Application for a Non-Material Amendment Following a Grant of Planning Permission

Two storey side extension following demolition of existing attached garage, single storey rear extension, loft conversion with dormer to rear roofscape, porch to front, and outbuilding to rear

22/02425/FUL

P-002 revision B

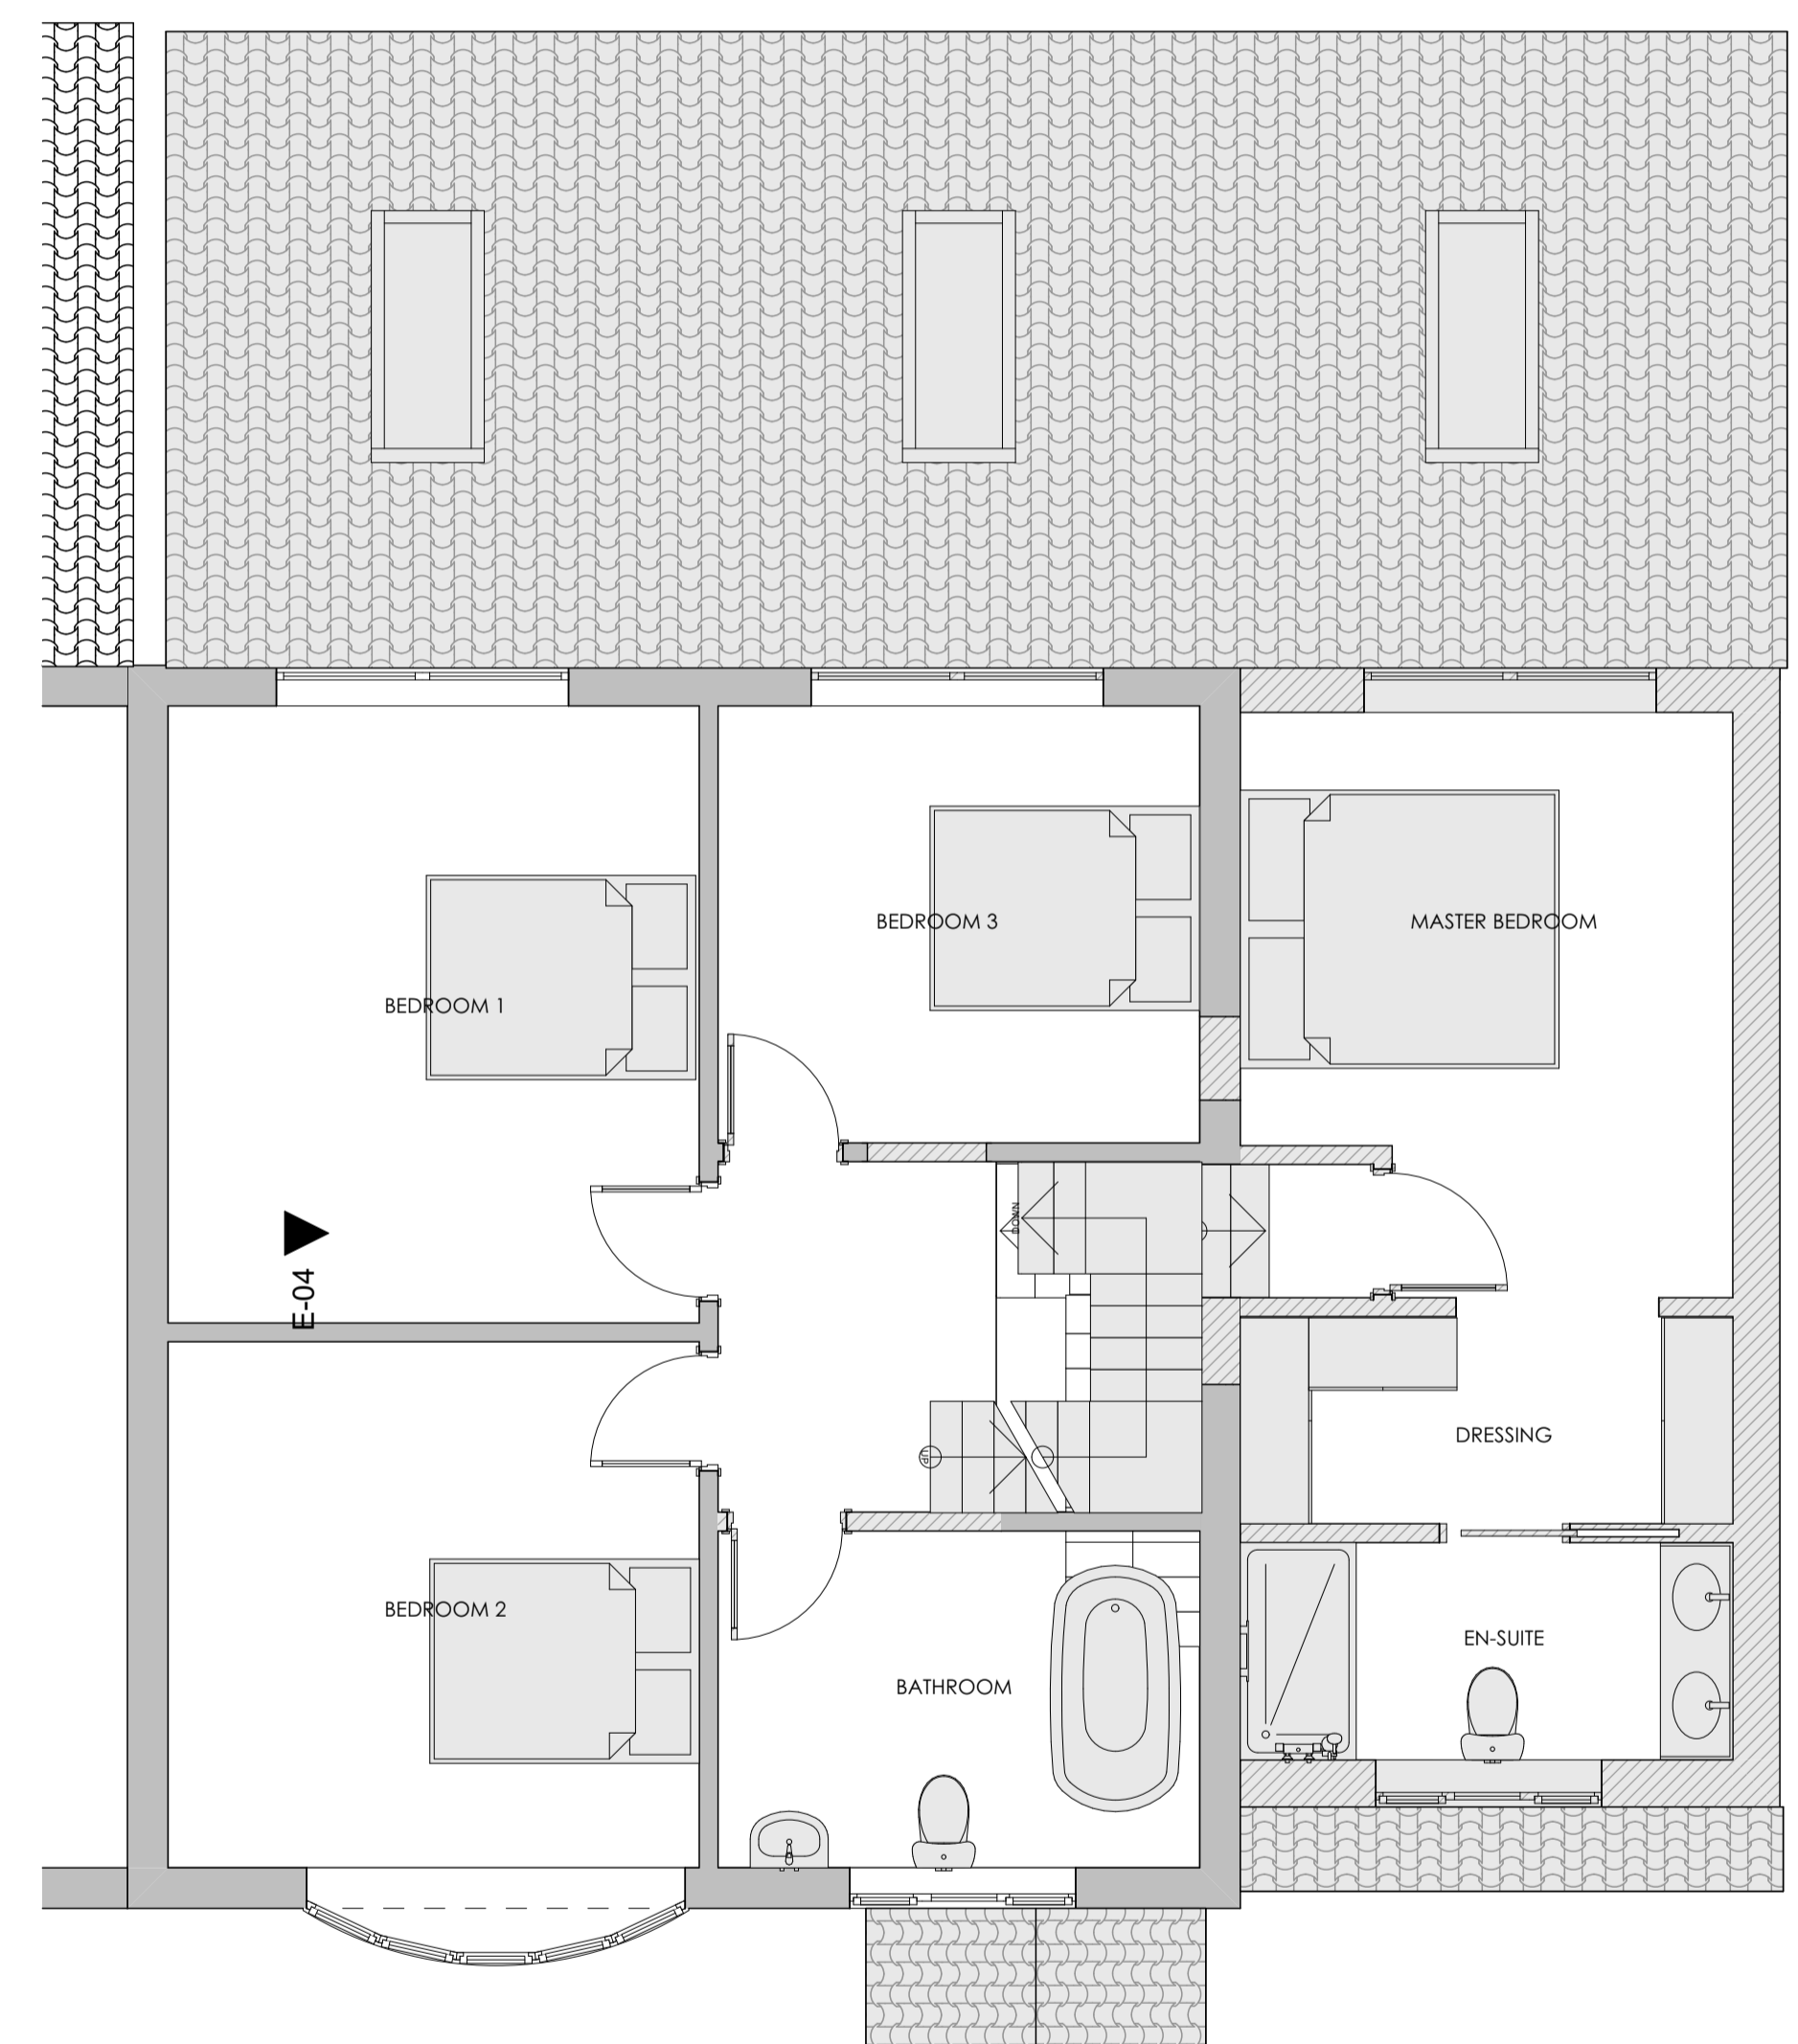
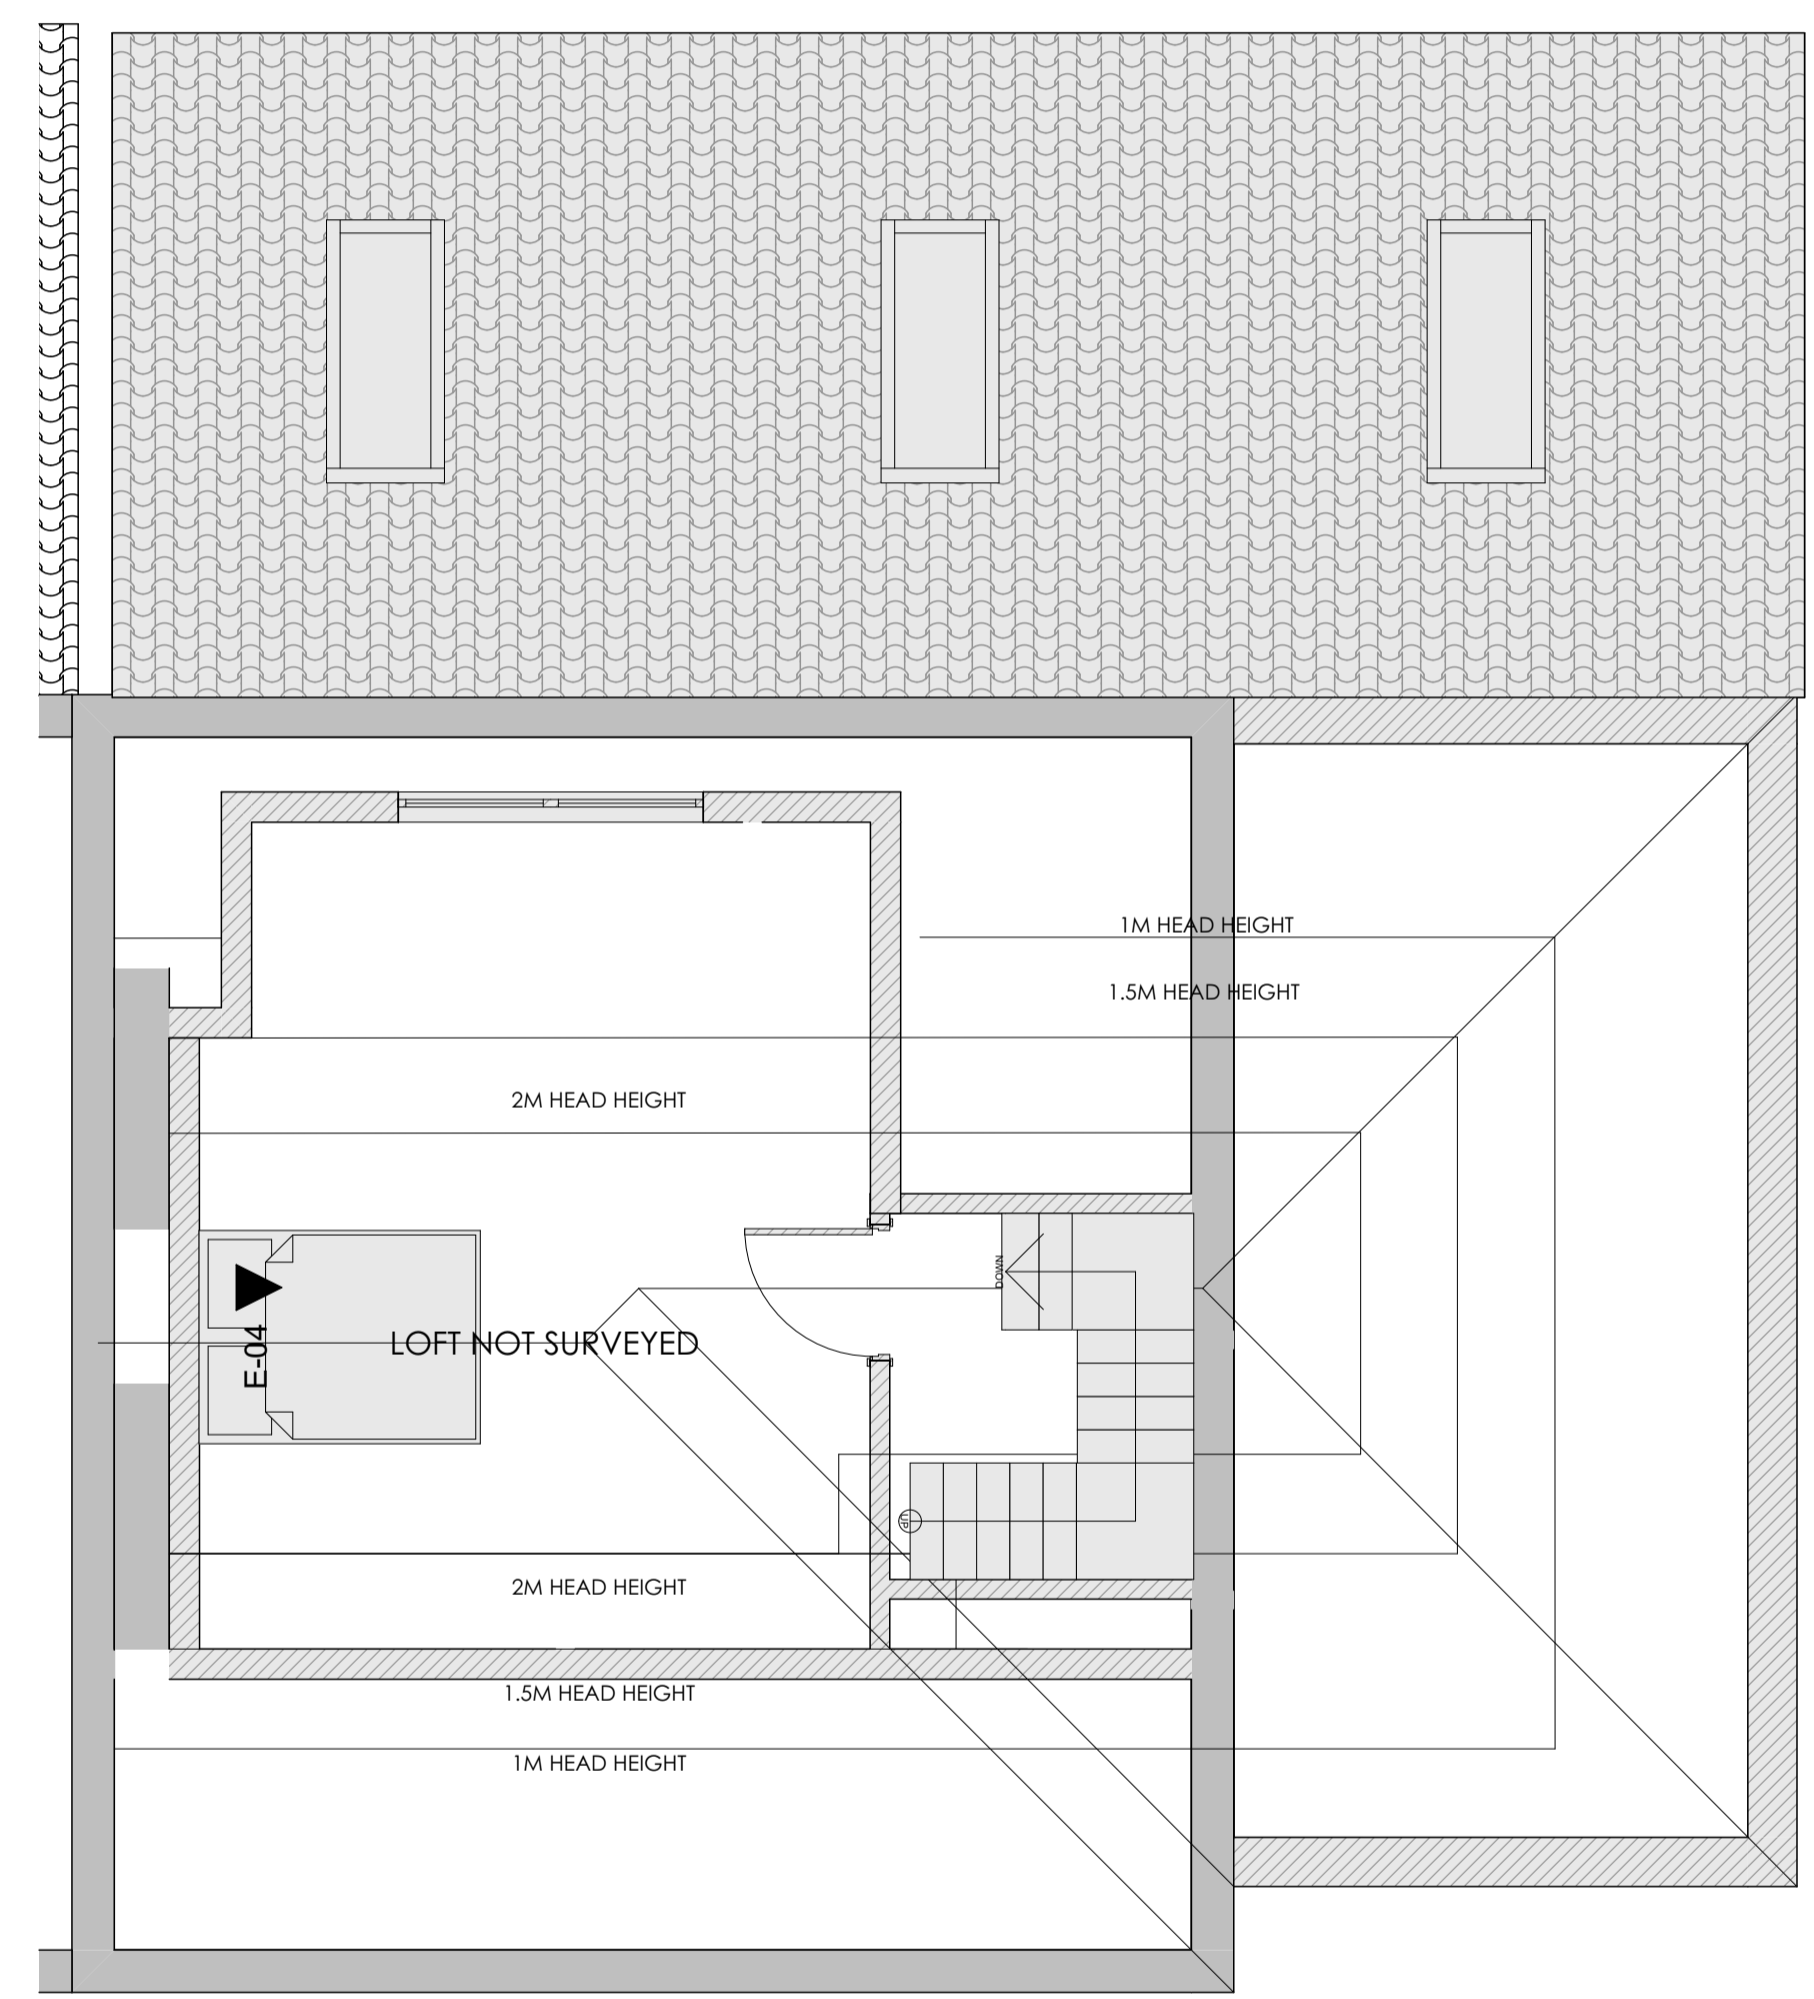
To remove the first floor window on the east elevation (2)
To remove one rooflight on the extension pitched roof to have a total number of 3 skylights.
